**Heritage Council**

**RE: SSI – 4963 Pacific Highway Upgrade — Woolgoolga to Ballina Project  
– Public Exhibition of the Environmental Impact Statement**

This letter has been prepared following review of the documents forming the Environmental Impact Statement for the Pacific Highway Upgrade — Woolgoolga to Ballina Project.

Figure 13-12: Heritage curtilage of High Conservation Value Old Growth Forest

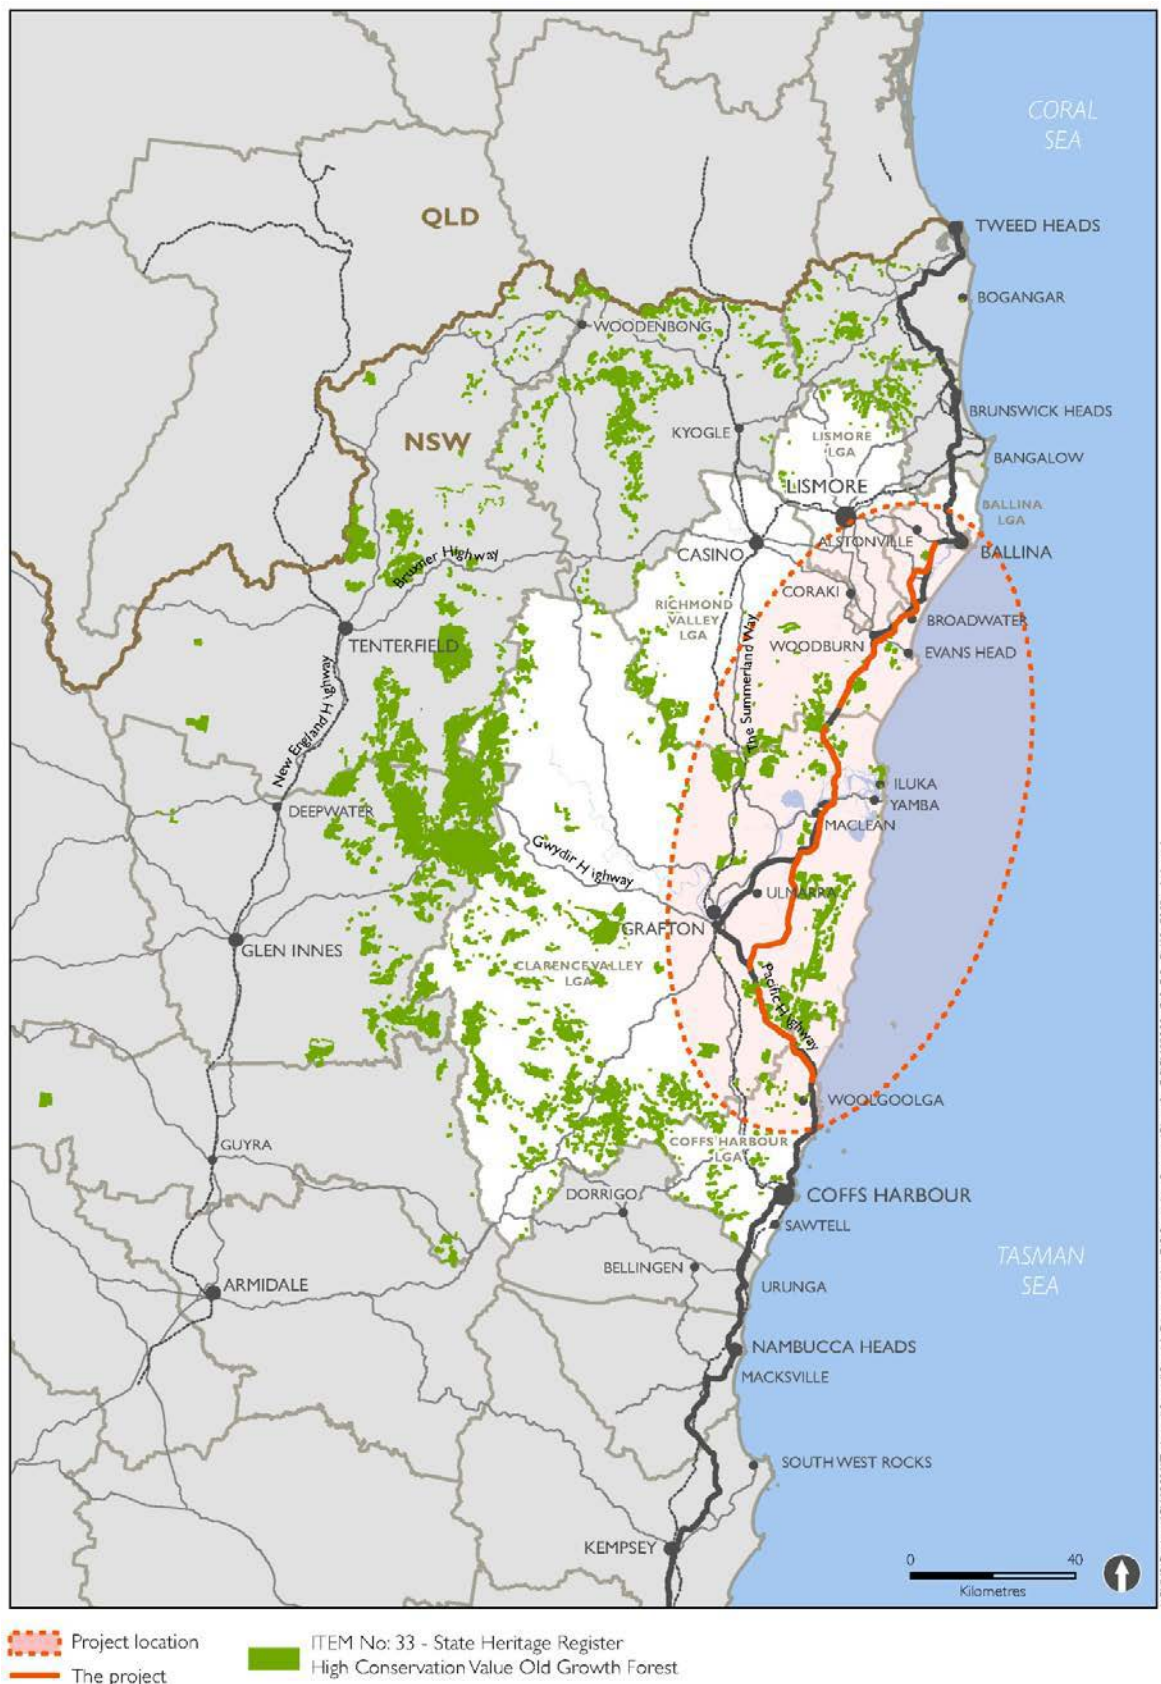
The Heritage Branch provided comment on the draft EIS by letter dated 1 November 2012. That letter specifically suggested that additional information should be provided regarding the assessment of the impact on the High Conservation Value Old Growth Forest and that some increased explanation of the relationship to the biodiversity offset strategy being development for the whole project would be desirable. It is noted that the Heritage component of the exhibited EIS document has not provided any additional level of information than previously. Therefore the previous comment stands and has not been addressed in the document reviewed.
